Bord Pleanála  
64 Marlborough Street  
Dublin 1

8 January 2021  
Case Number: ABP -308358-20  
Planning Authority Reference number: EC15-20

**Re:** Whether a garage/store to the side and single storey extension to the rear of house is or is not development or is or is not exempted development.  
39 Kylemore, School House Road, Castletroy, Co. Limerick

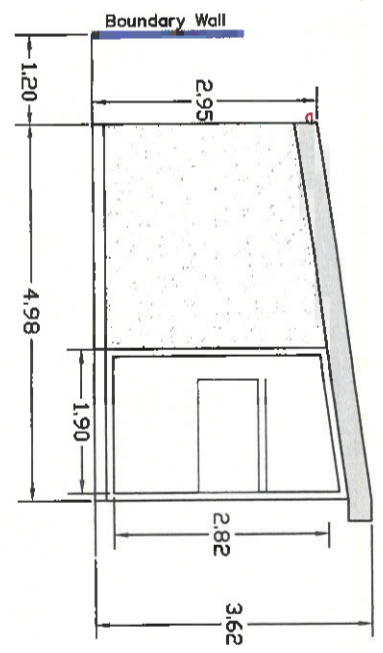
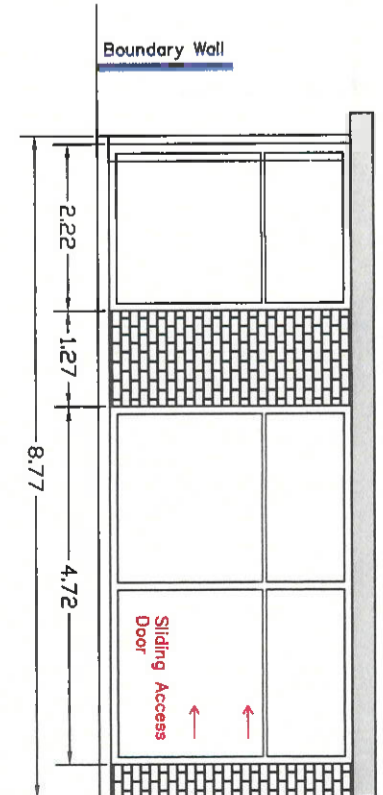
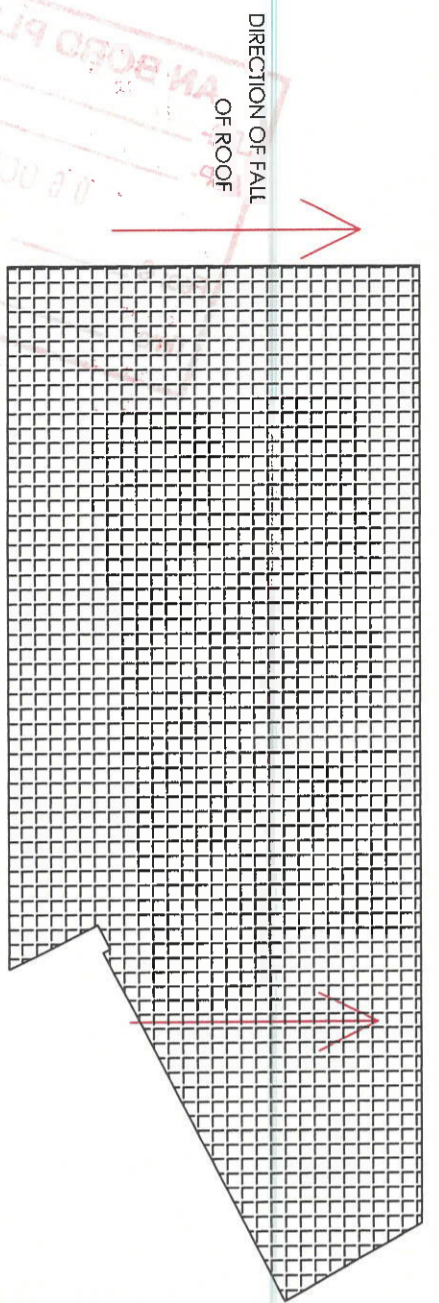
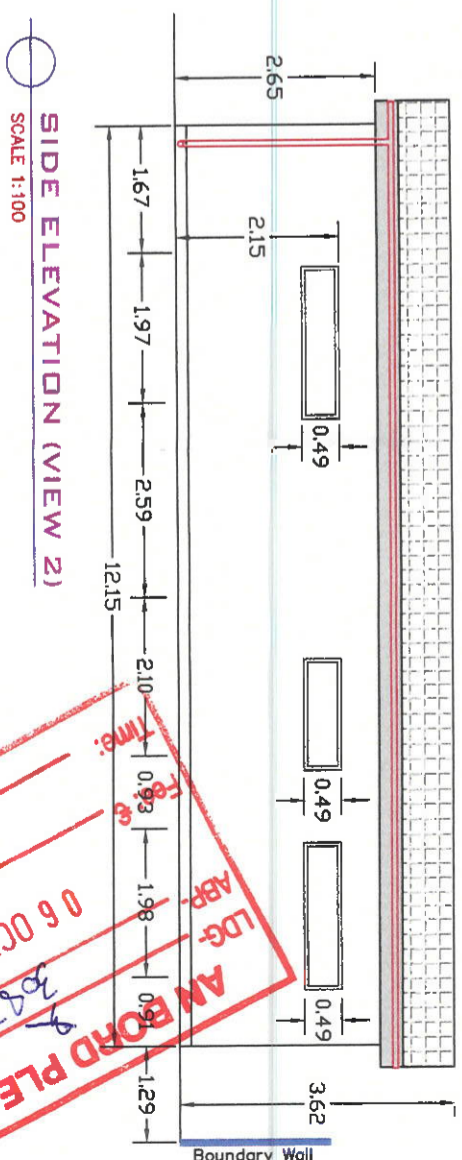
2. Notwithstanding the fact that a privacy shield is mentioned to be provided to the windows. The 'windows' on the boundary wall are still non the less, 'windows' and do not comply with paragraph 6(a) of the above-mentioned schedule of the regulations, i.e. they are windows that are less than 1m from the boundary it faces. The south/rear corner windows of the annex are 0.9m to the boundary wall. The corner returning windows on the south east elevation also are within 1 meter of the boundary wall (refer to applicant's site layout and elevation drawings ref 17-76-002 and 17-76-004 submitted to Limerick City and County Council on the 18-7-2017).

3. The height of the garage/ store portion of the development at 3.62m high far exceeds the 3m maximum height permitted in paragraph 5 Class 3 of the above schedule for non tiled roof of garages/ stores. In this regard, we are strongly of the view that the metal deck roof on this property, although it has a low pitch, is not a "tiled roof or slated roof" as stipulated in this clause. The roof pitch is indicated at 9°. This low pitch would be considered in construction terms as a flat roof and in actual fact, is defined as such in the Harris Dictionary of Architecture, where it is stated that, 'any pitch less than 10° is deemed to be a flat roof'. In addition, it is stated in Class 3 paragraph 4 of the above-mentioned regulation that, *"The external finishes of any garage or other structure constructed, erected or placed to the side of a house, and the roof covering where any such structure has a tiled or slated roof, shall conform with those of the house."* We would be sincerely of the view that this condition has also not been met by virtue of the finishes of the building (See Apendix Pictures 1-4) and the proposed application.

4. With reference to BDB Consulting letter to An Bord Pleanála (Date November 2<sup>nd</sup>, Ref 17-76) point 4 – "*all possibility of overlooking is entirely eliminated and the rear window omitted*". Section 5 Drawings show no change to glazing except privacy shield to some windows which is a farcical solution. The extent of glazing from floor to roof and the surrounding windows on all walls of the extension clearly overlook adjacent properties and provide no means of any privacy at all which can be seen in Pictures 1-4 (Appendix A).

7. There are a number of irregularities evident in the drawings as submitted which would call into question the validity of the application namely;
  - We would have concerns about the accuracy of the floor areas as indicated for the extension in that from scaling the submitted floor plan, the overall area of the garage and music room area would appear to exceed 40 m<sup>2</sup>. Whereas the submitted Section 5 drawings indicate this combined area to be 39.8sq.m. Again additional credence is given to this observation by the fact that the area originally indicated on the retention planning drawings of this combined area was indicated by the applicant as being 41.5 m<sup>2</sup> (reference Planning Drawing no. 17-76-002).

- The distance indicated from the rear wall of the annex to the rear boundary is indicated at 1.03m on the submitted Section 5 site plan. It was however indicated on the retention planning application drawings on both the floor plan and site layout plan as being 900mm (reference Planning Drawing no's 17-76-002 and 17-76-004). We are at a loss to understand how this dimension can change between the two applications in an established structure/ site. Clarification on this ambiguity is clearly required here for the reasons as highlighted above.

- It is not indicated on the submitted drawing that there is currently a wide ope which links the existing house and the current proposed garage location. No indication or other reference to this ope has been submitted on the submitted drawings and indeed this was the case with the previous retention application. Currently there is access to this from the main dwelling at the side/corner of the house which is not indicated on any plans.
